Project: 115201-5.3.1.5

**RE: RESPONSE TO COMMENTS LETTER  
380 ROLLING MEADOW CRESCENT – SUBMISSION #1**

With reference to the above mentioned submission and your comments in your Memorandum dated December 24, 2018, please see our responses below:

010

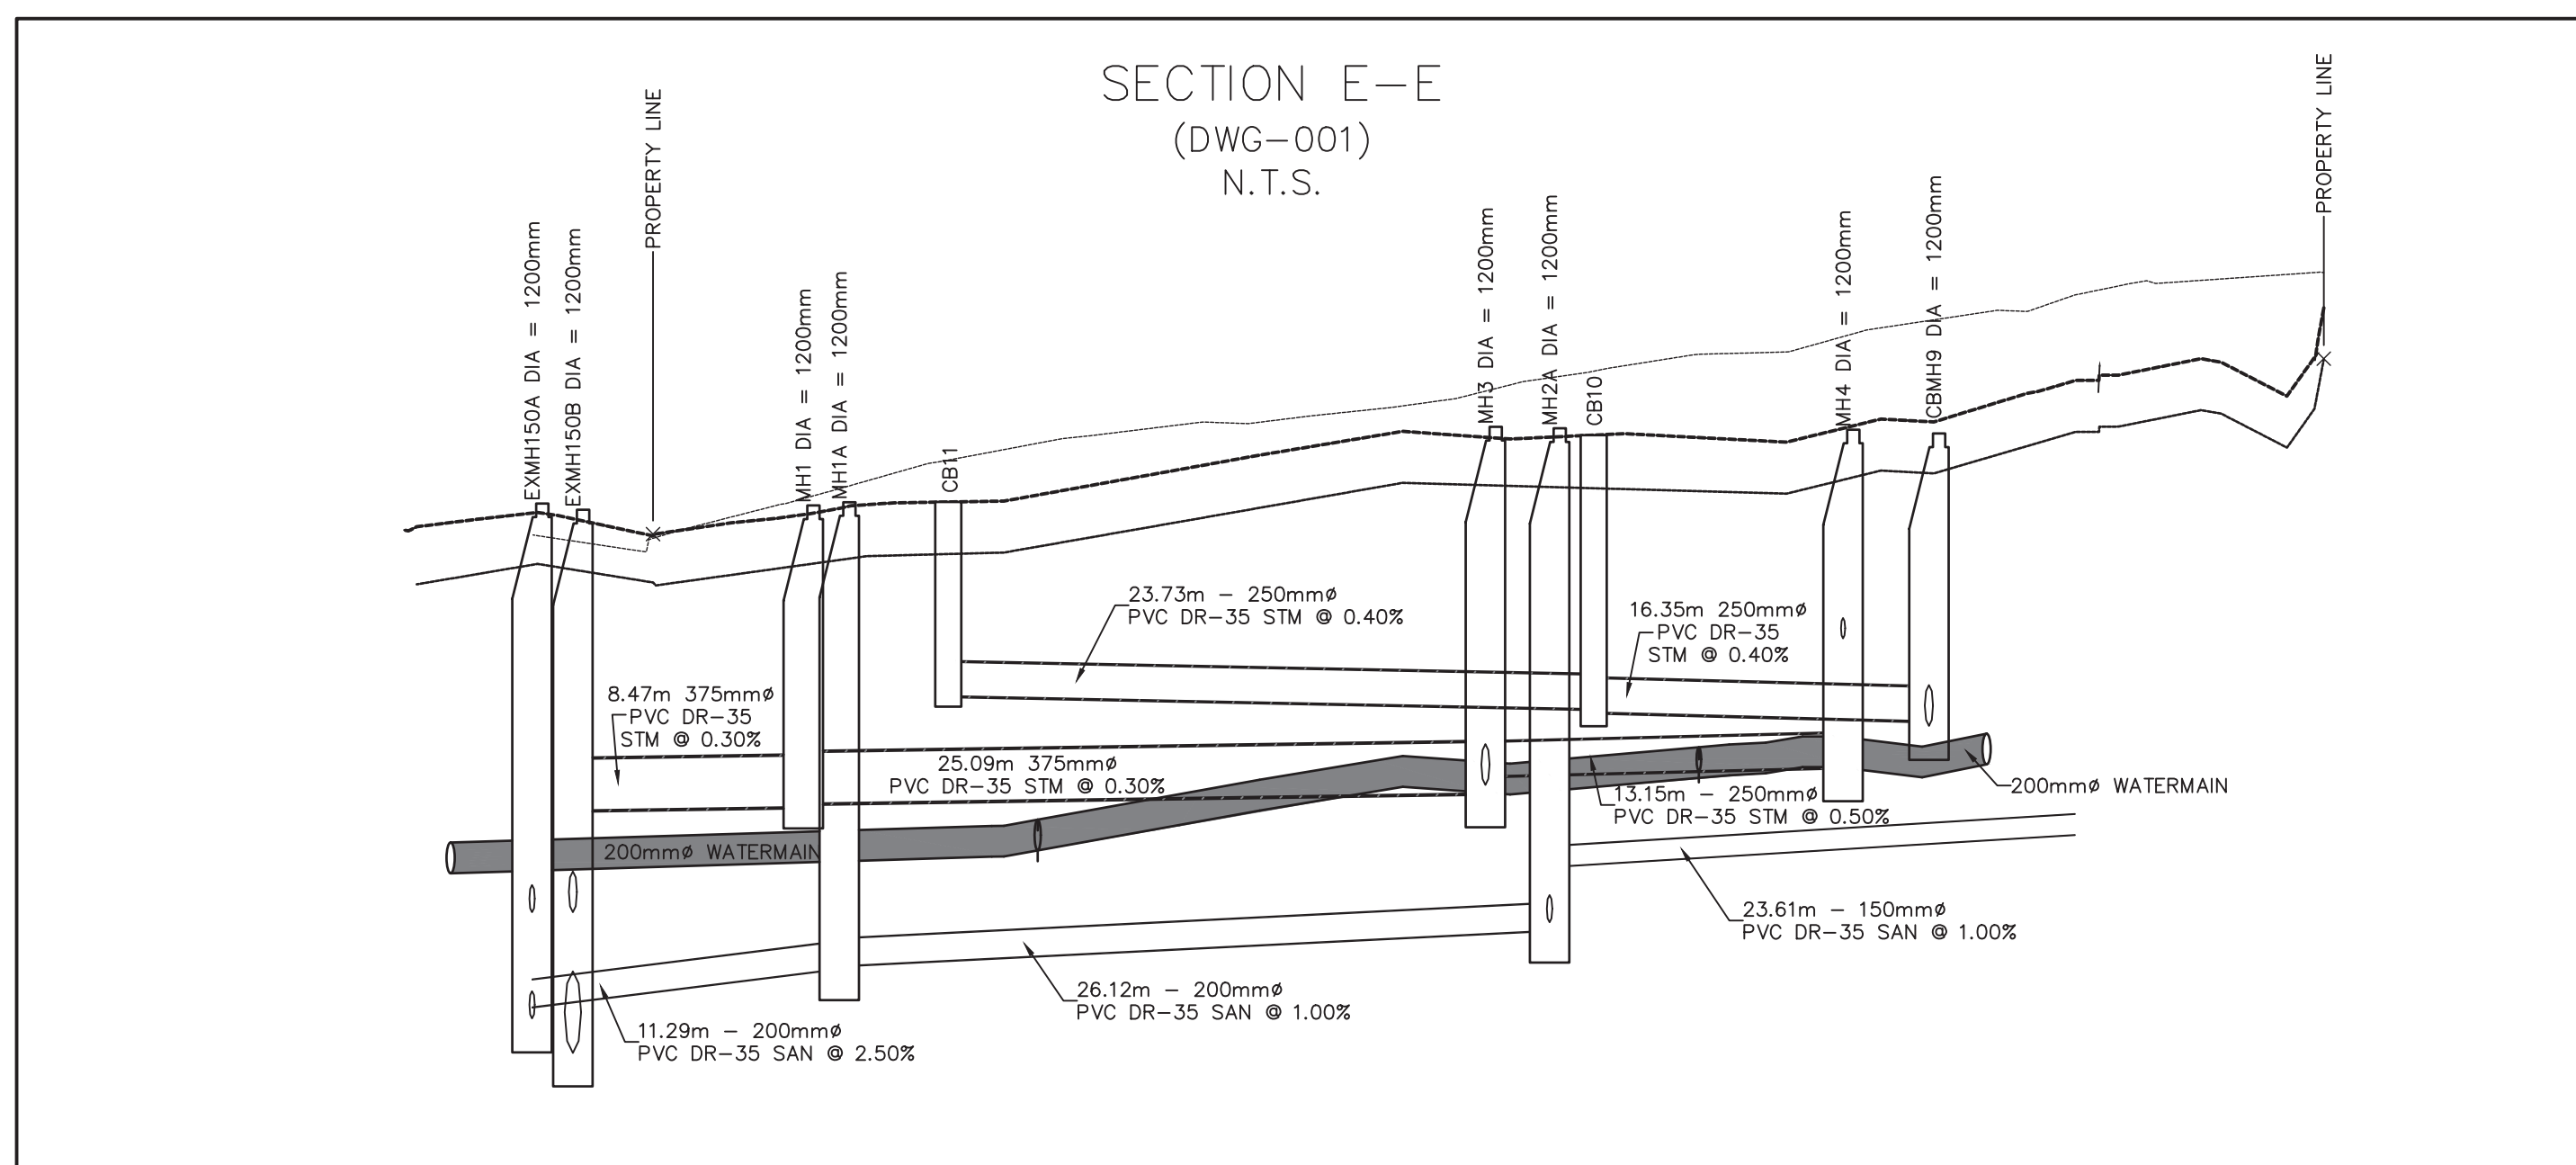
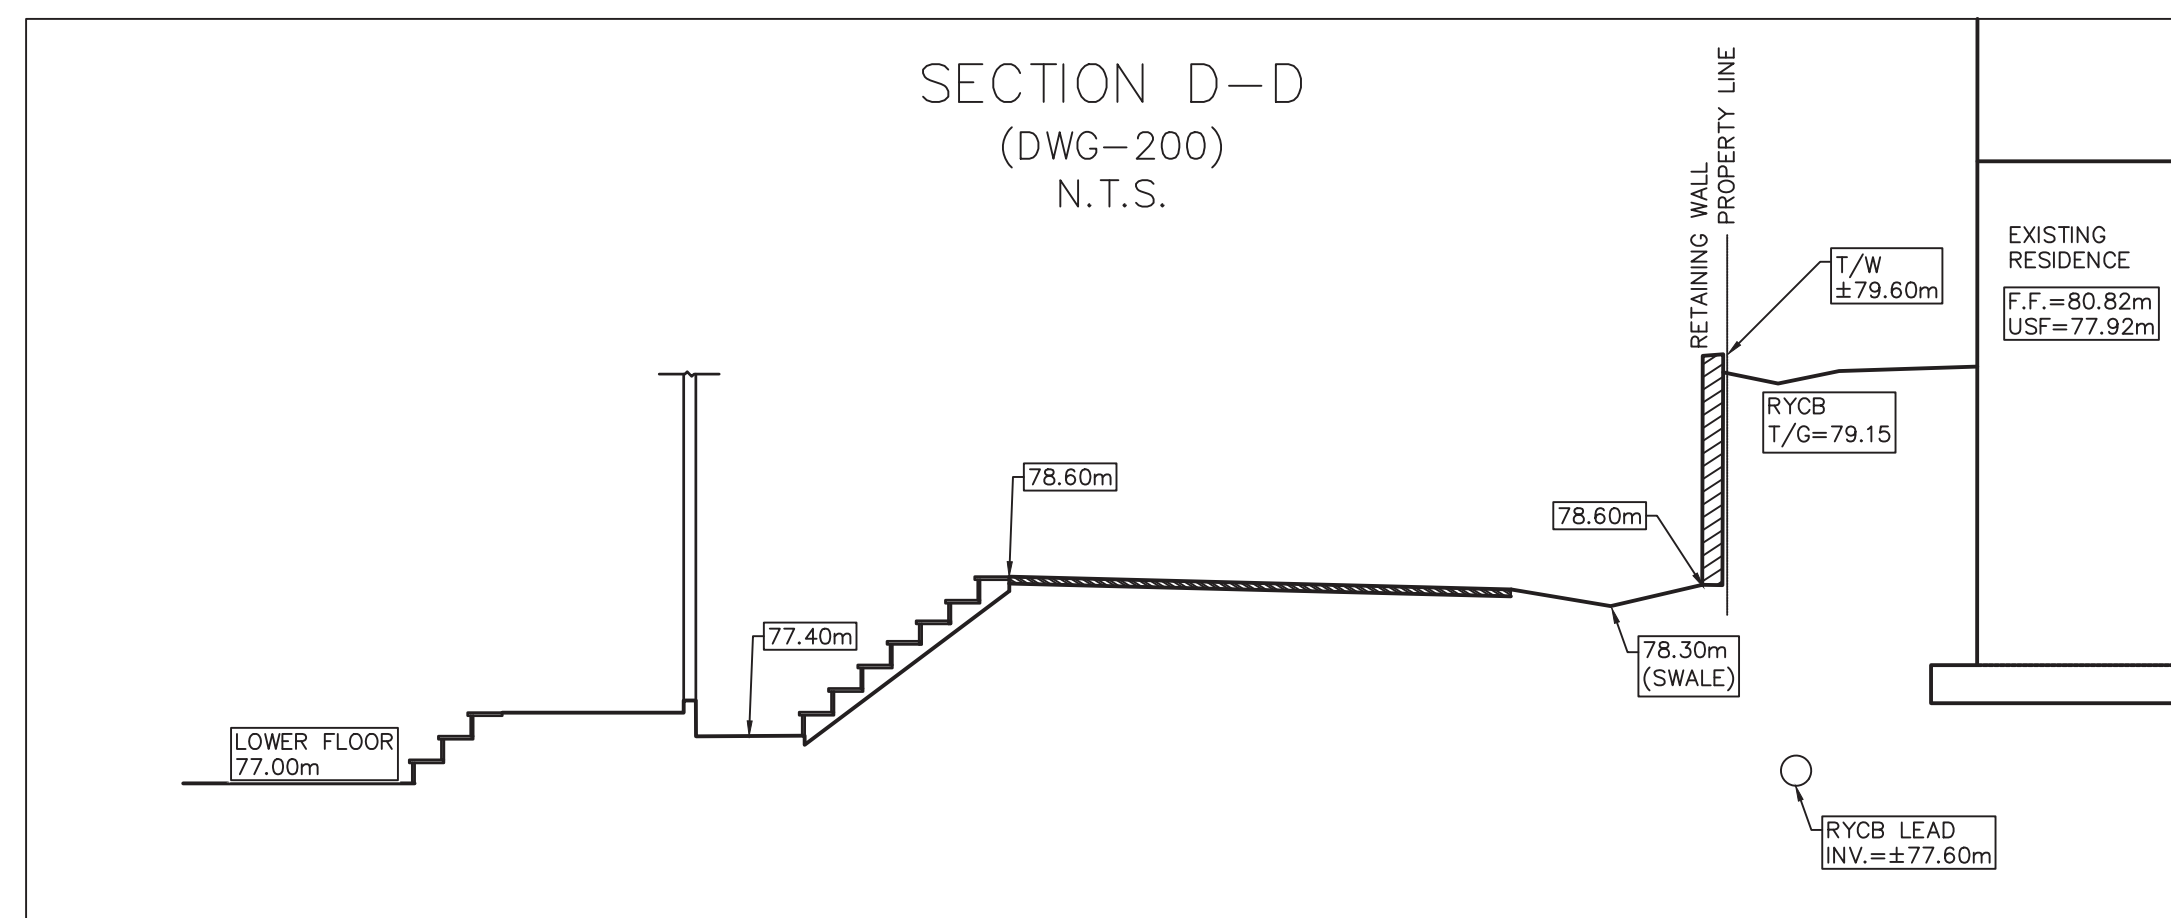
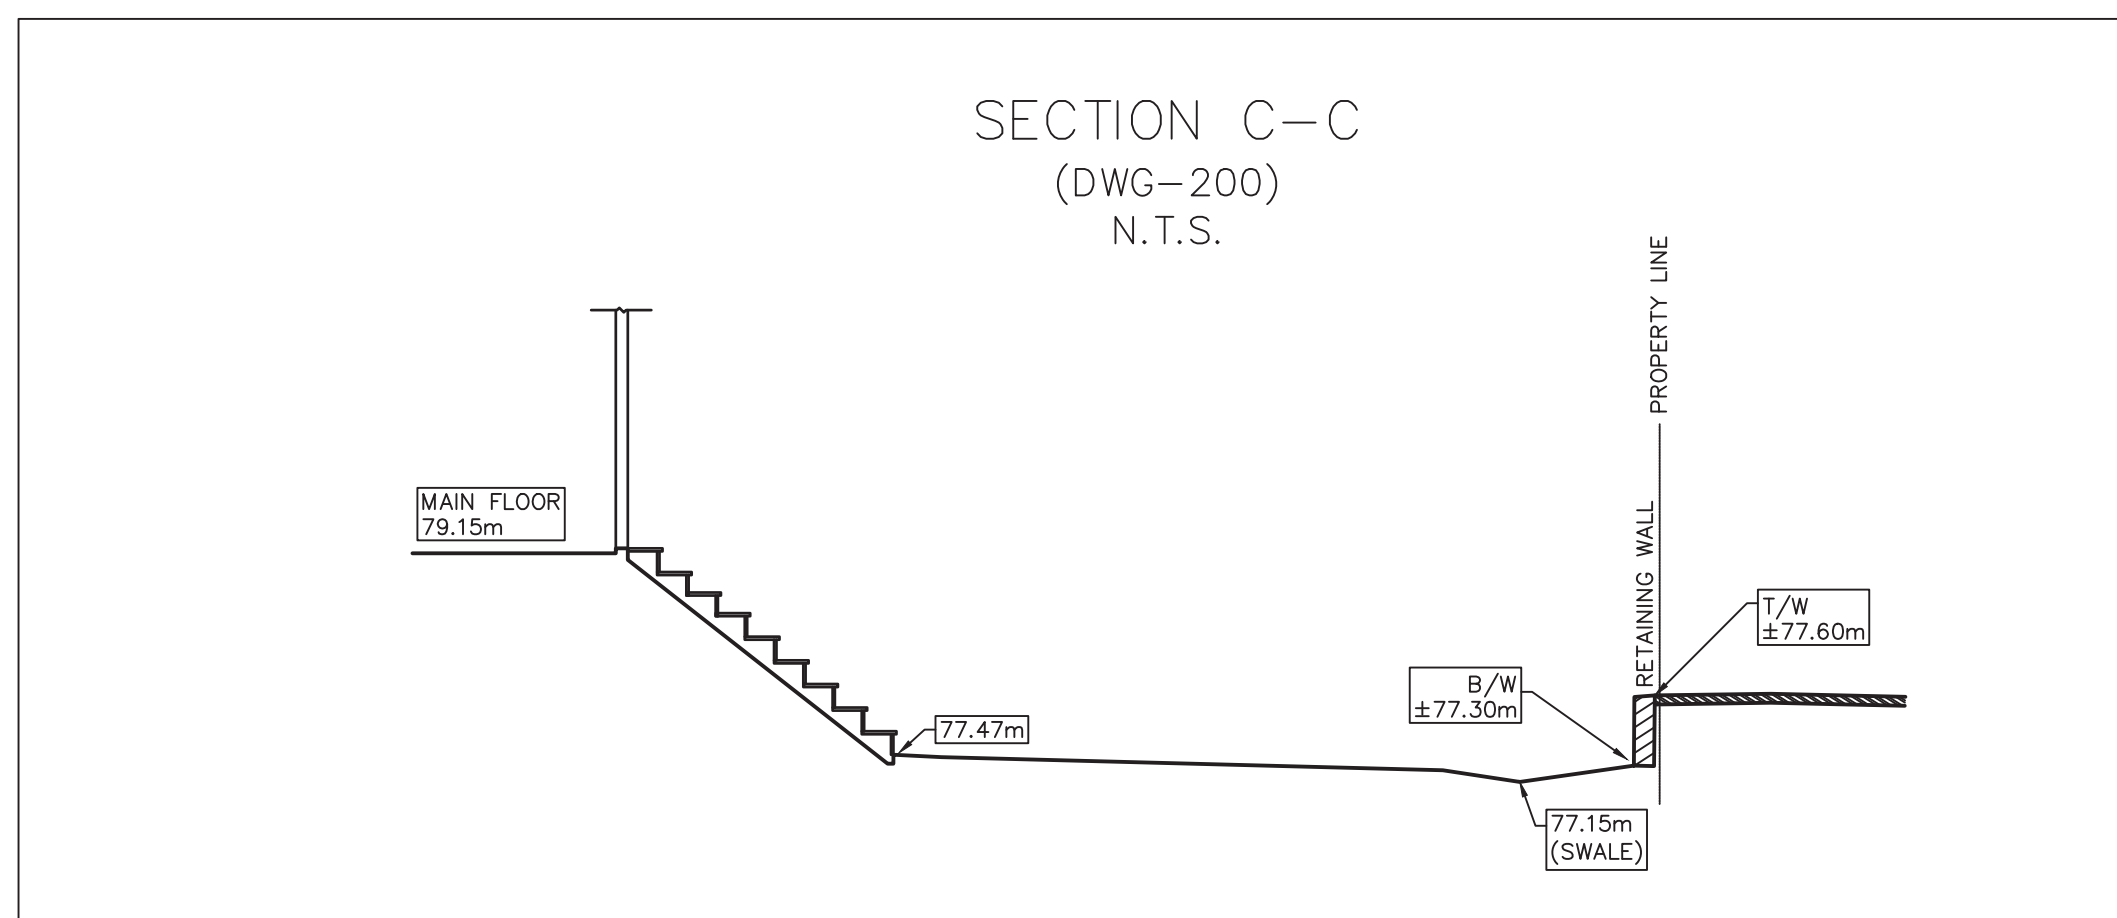
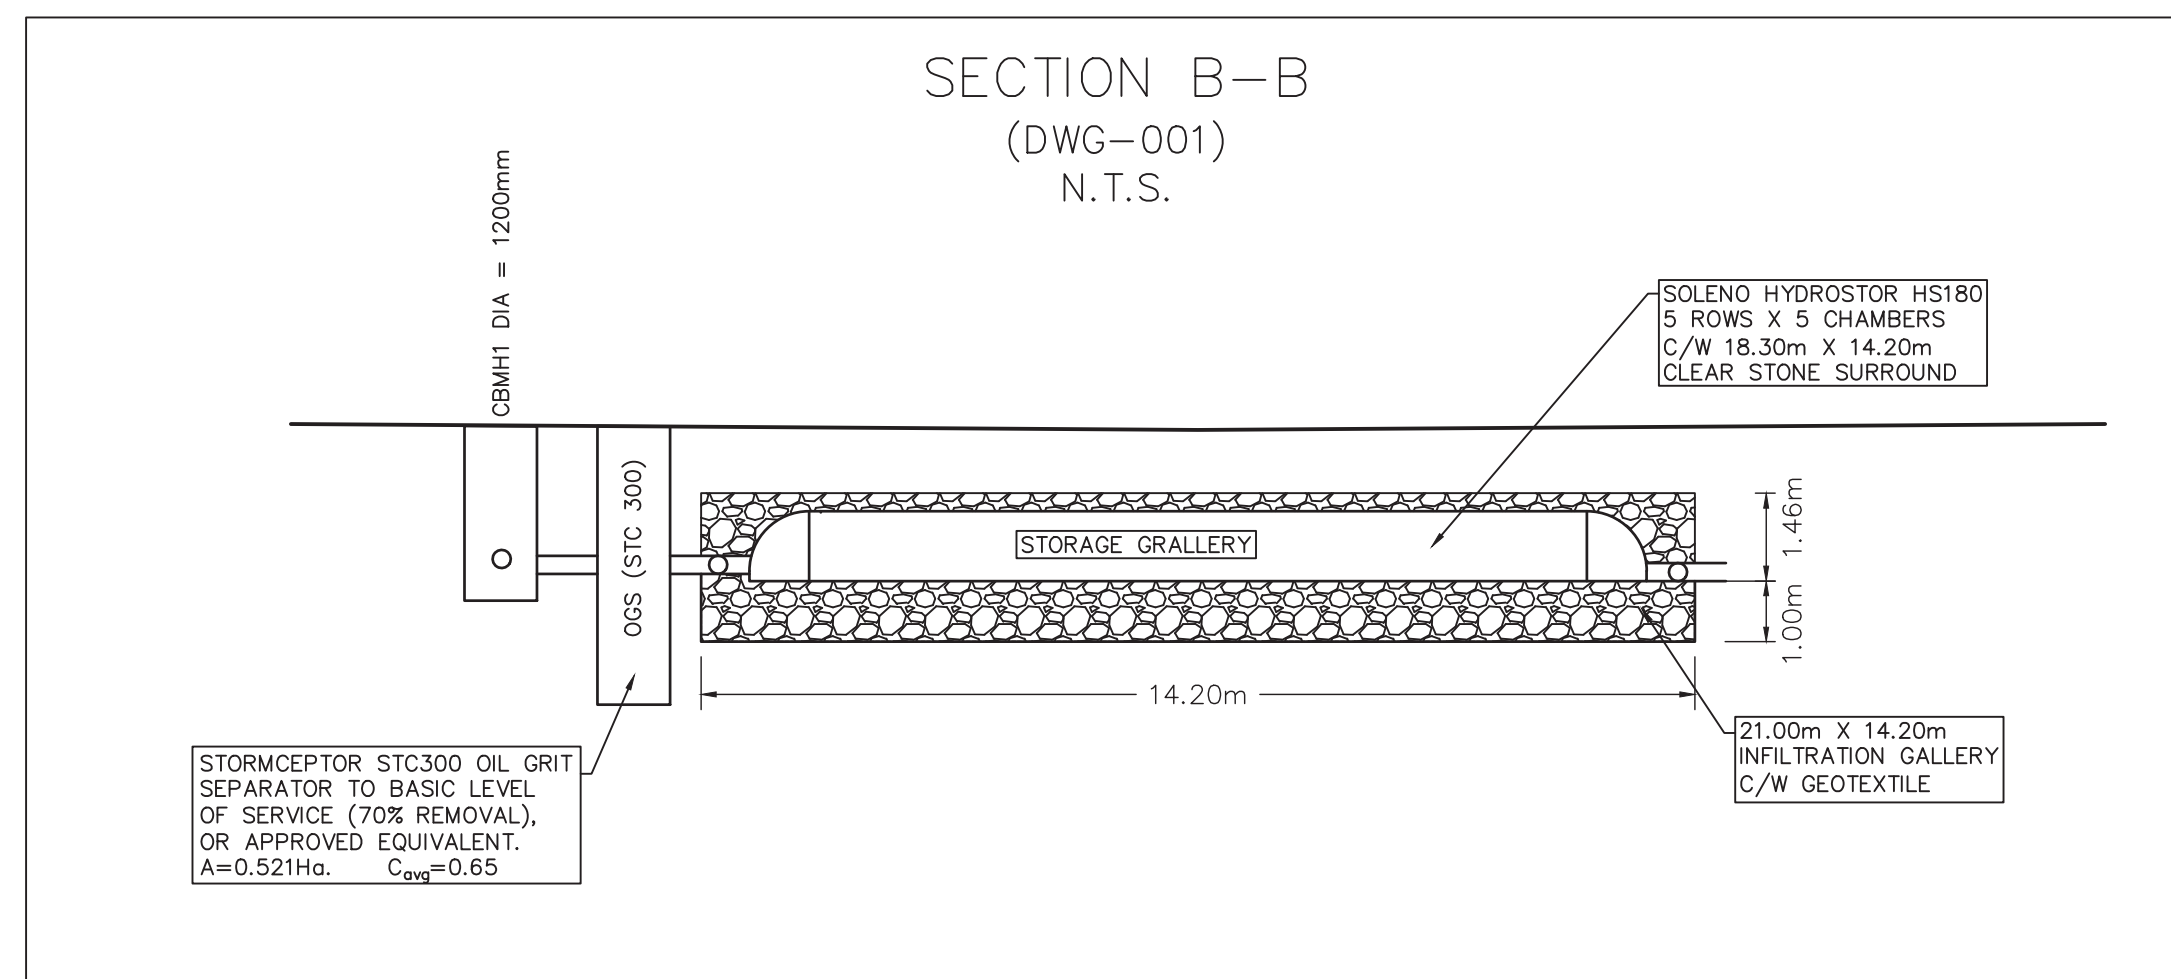
42. Ensure that all symbols listed in the Legend are referenced to the appropriate standards, as required. Likewise, ensure that all symbols shown on the drawings are listed in the Legend (ex.: floor drain on Grading Plan not shown on the Legend).

43. The CB Data Table is listed on Drawing No. 001 – General Plan of Servicing and not on this drawing.

*Floor drain symbol added to legend.*

*CB Table removed from title block.*
